Lake Lyell Pumped Hydro Energy Storage Submission (SUB-118132238)

Submission by Dr Jane T. Aiken

RE: LAKE LYELL PUMPED HYDRO ENERGY STORAGE (PHES)

APPLICATION NO: SSI-77018220

Figure 3.11 Planned sequencing of Lake Lyell diversion, Farmers Creek infill and inlet / outlet structure

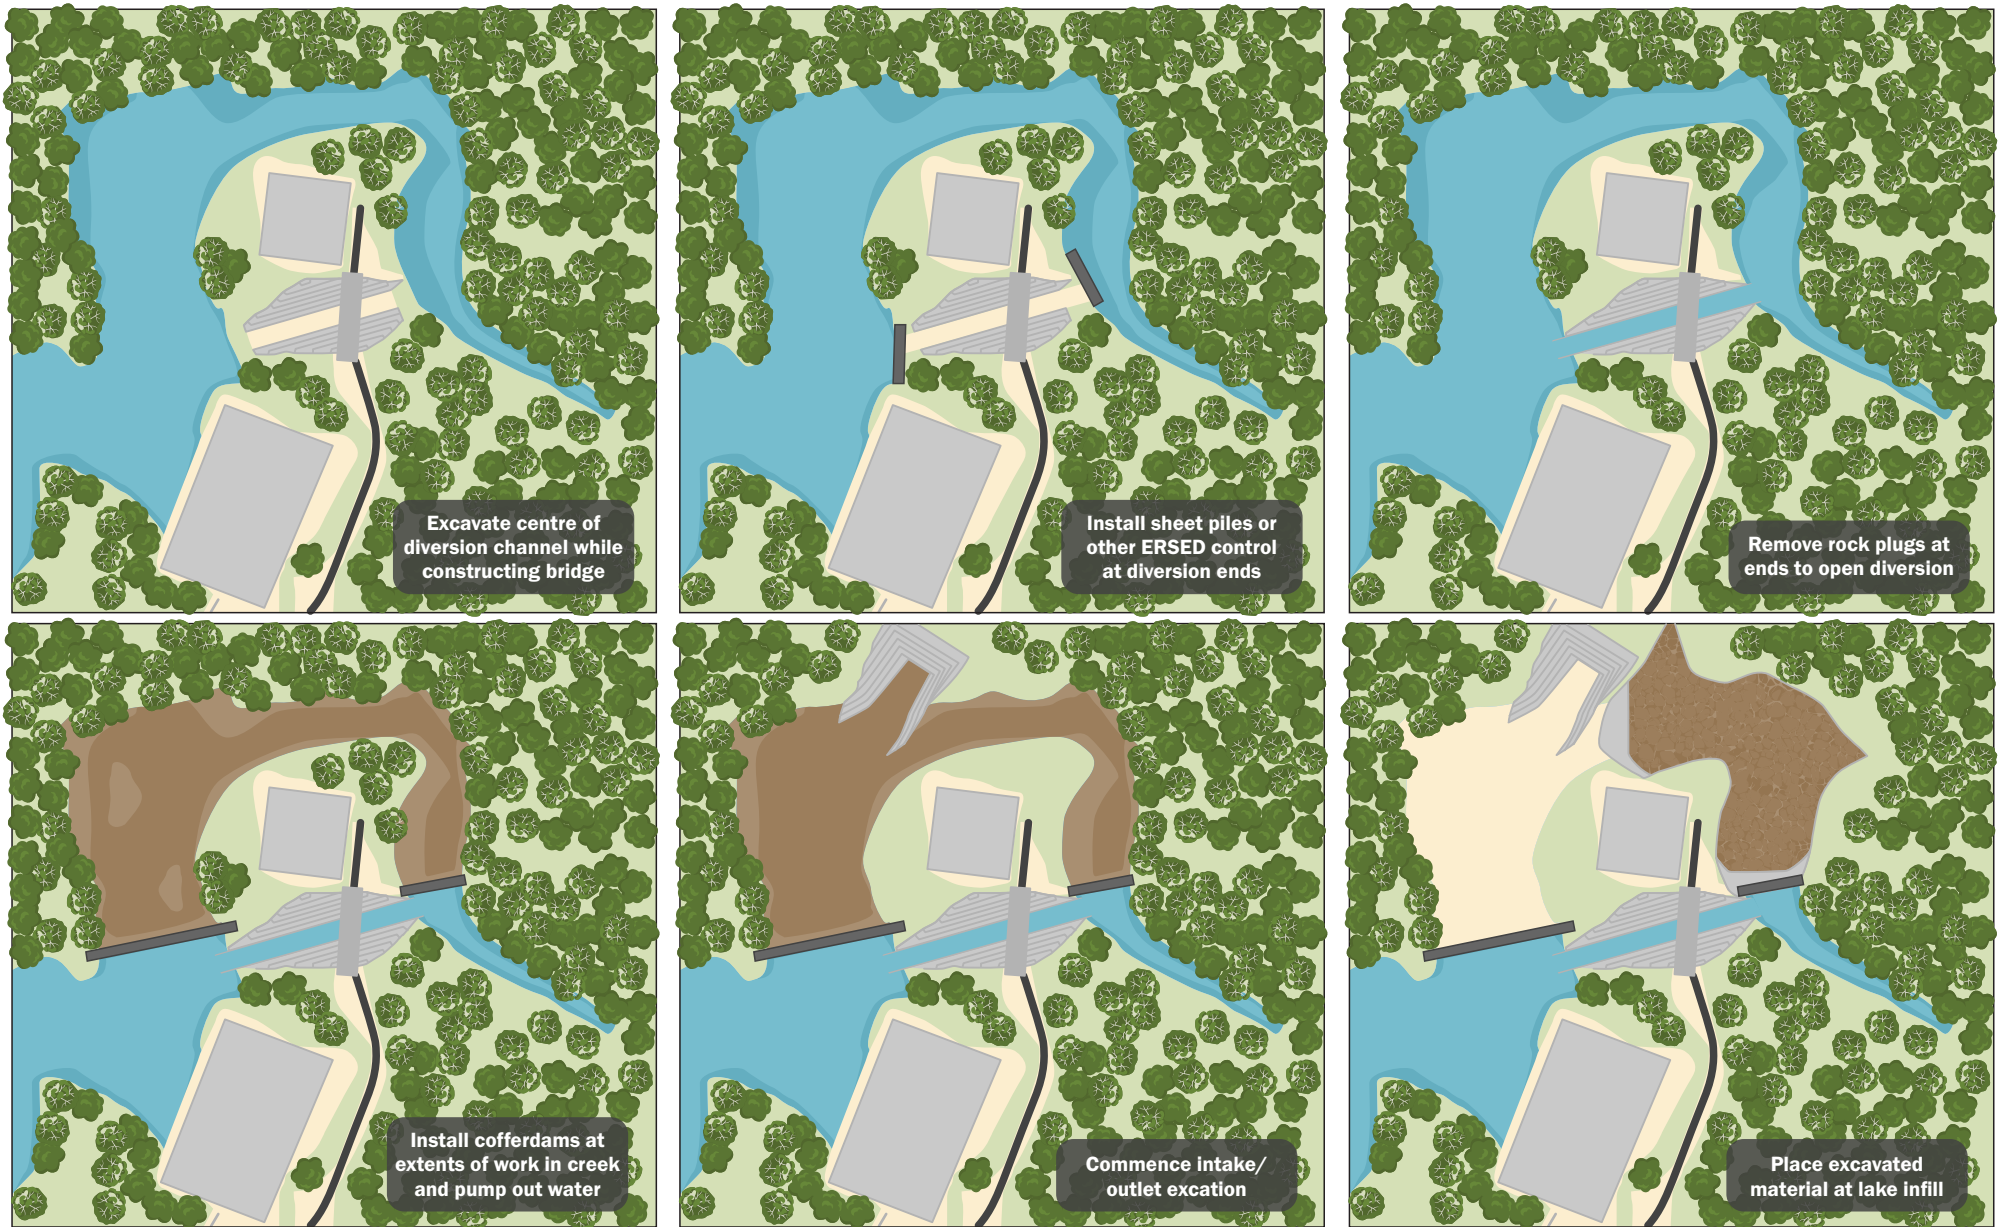
The EIS suggests a lack of detail regarding immediate impacts to the confluence of Farmers Creek, Coxs River and the inlet/outlet.

While Appendix F (Annexure G) identifies a daily pumping and release cycle and includes cross-sectional and velocity-based analysis, this information is not integrated into a cumulative assessment of hydrological interactions. In particular, the combined effects of discharge at the Farmers Creek diversion, inflows from the Coxs River, and broader lake level fluctuations are not assessed in a coordinated manner.

As a result, the magnitude, frequency, and spatial distribution of impacts are not fully characterised under realistic operational conditions, and the scale, and interaction of impacts—particularly within the lower reaches of Farmers Creek—are not clearly characterised.

- *No assessment of cumulative interactions between pumping, discharge at Farmers Creek diversion, Coxs River inflows, and lake level fluctuations.*
- *EIS does not identify or assess the lower reaches of Farmers Creek as the primary operational impact zone, some information is found in the Annexure G of Appendix F.*
- *Limited ability to characterise spatial distribution of impacts and assess downstream and localised hydrological effects.*

Details relevant to the primary impact zone, including the potential for bank and lakebed scouring, are presented in Annexure G (Cross-section Average Velocity Calculations) of Appendix F (Surface Water Assessment) of the EIS. The annexure states that the Lake Lyell PHES scheme will typically operate on a daily cycle, comprising a generation phase (discharge to Lake Lyell) and a recharge phase (pumping to the upper reservoir). Peak flow rates of approximately 210 m³/s for discharge and 190 m³/s for pumping from the Farmers Creek arm are identified, with the potential to cause erosion of sediments along the lakebed and banks.

To assess erosion risk, the annexure presents calculations of average (uniform) flow velocities across a series of cross-sections within the Farmers Creek arm, based on the maximum discharge flow of 210 m³/s. These calculations are described as approximations derived from assumed cross-sectional areas and simplified flow conditions. A total of 12 cross-sections were analysed over a distance of approximately 600 metres downstream of the pipe outflow, representing largely natural bed conditions, with some sections (5, 6 and 7) incorporating proposed laydown infill. The creek bed profiles are illustrated in Figure G.2, and Table G.1 presents calculated velocities across a range of lake levels (approximately 780 m, 781 m, and 784.5 m AHD) for peak flow conditions.

As a result, the magnitude, spatial extent, and persistence of erosion risk within the Farmers Creek arm are not fully characterised. The potential for cumulative impacts under repeated operational cycles—such as progressive bank instability, sediment mobilisation, and downstream effects—remains uncertain. This limits the ability to clearly link identified impacts within the primary impact zone to specific, enforceable mitigation measures, and to demonstrate how these impacts would be effectively managed over the operational life of the project.
